SUBJECT: WDFW COMMENTS ON CU-24-00006 Silver Ridge Ranch

Thank you for the opportunity to comment on CU-24-00006, Silver Ridge Ranch's proposal to amend CU-2-07 to include use of an amphitheater and approval for conversion of a storage barn to be utilized as an event space. The Washington Department of Fish and Wildlife (WDFW) has reviewed the application and supporting documents on file. Upon review, we noted discrepancies between the project narrative, site plans and SEPA Checklist. We are submitting the following comments to be considered in review of the proposal prior to making a final determination.

SHEET:
SP-5

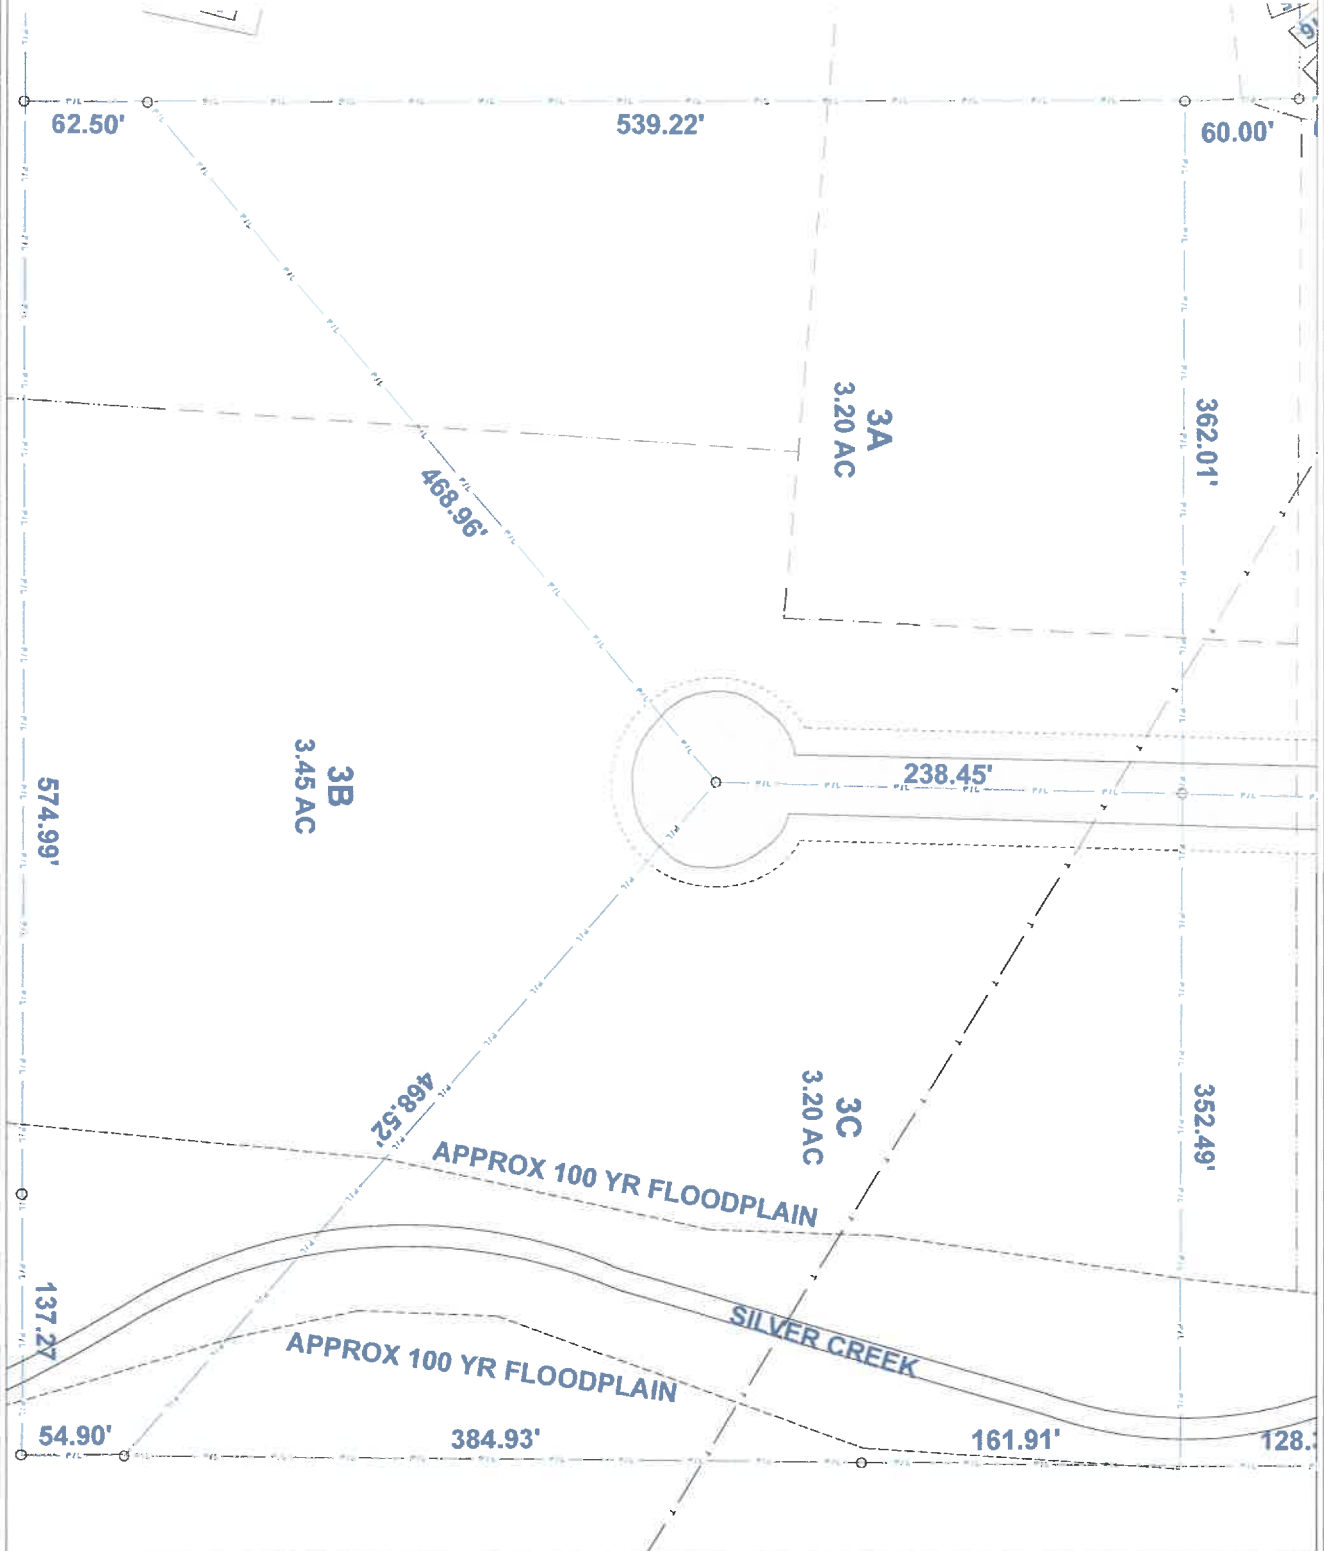
The site plans on file show existing access roads that are not evident on recent aerial photography. For example, the site plans show an existing cul-de-sac style access road on the 7 eastern parcels, which is not apparent on aerial photography.

Critical Areas Map

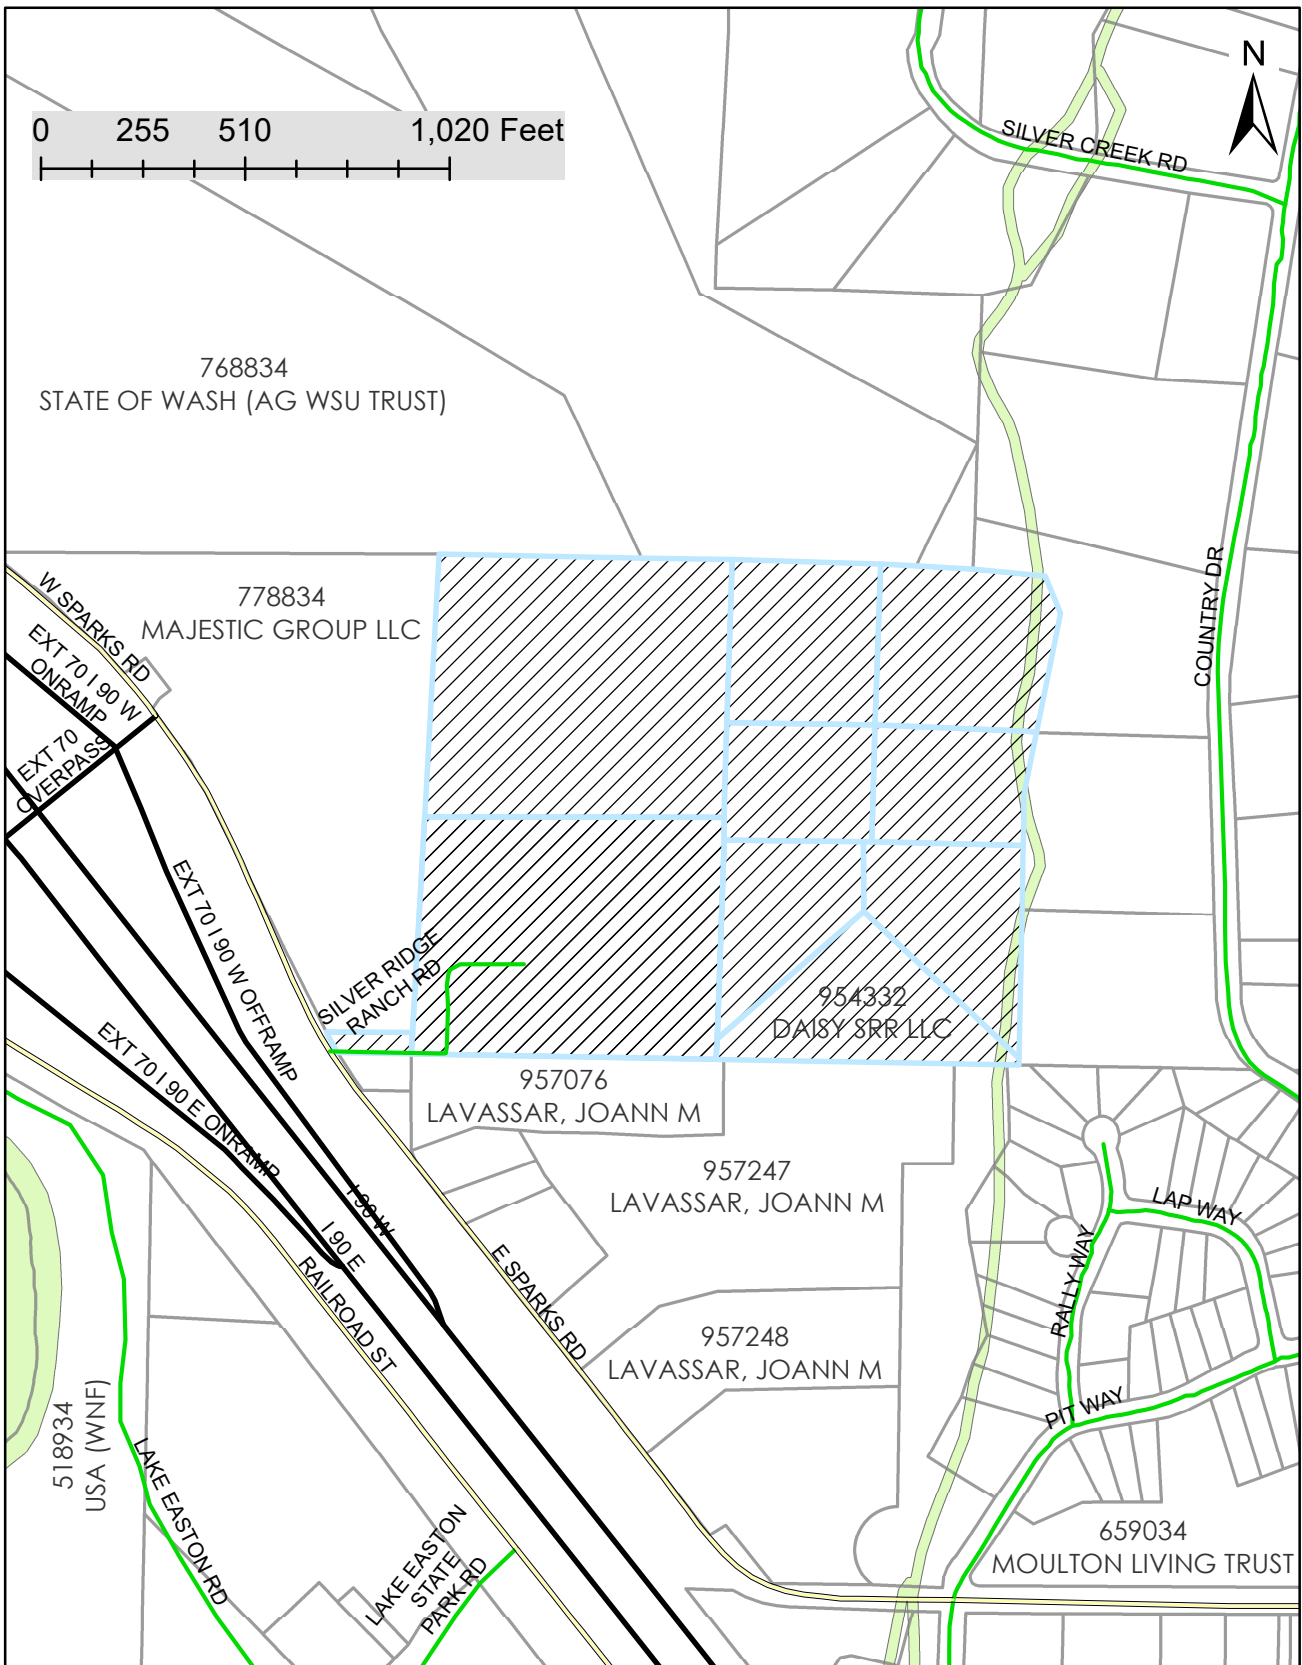
Parcels 954043, 954044, 954333 and 954332 all have portions mapped within the 100-year regulatory floodway of Silver Creek, a fish bearing tributary to the Yakima River and is a Shoreline stream for much of its length through the property. These parcels are mapped as Rural Conservancy and any proposed development should be reviewed for consistency with Kittitas County's Shoreline Master Plan and Critical Areas Ordinance.

While we appreciate the applicant has committed to not removing any trees or vegetation as part of the proposal, with the lack of clarity around the proposed project and site plan, and presence of known Shorelines and critical areas within the project area, WDFW recommends a full critical areas report be completed to identify all critical areas and ensure any impacts to them can be adequately mitigated for in the final project determination.
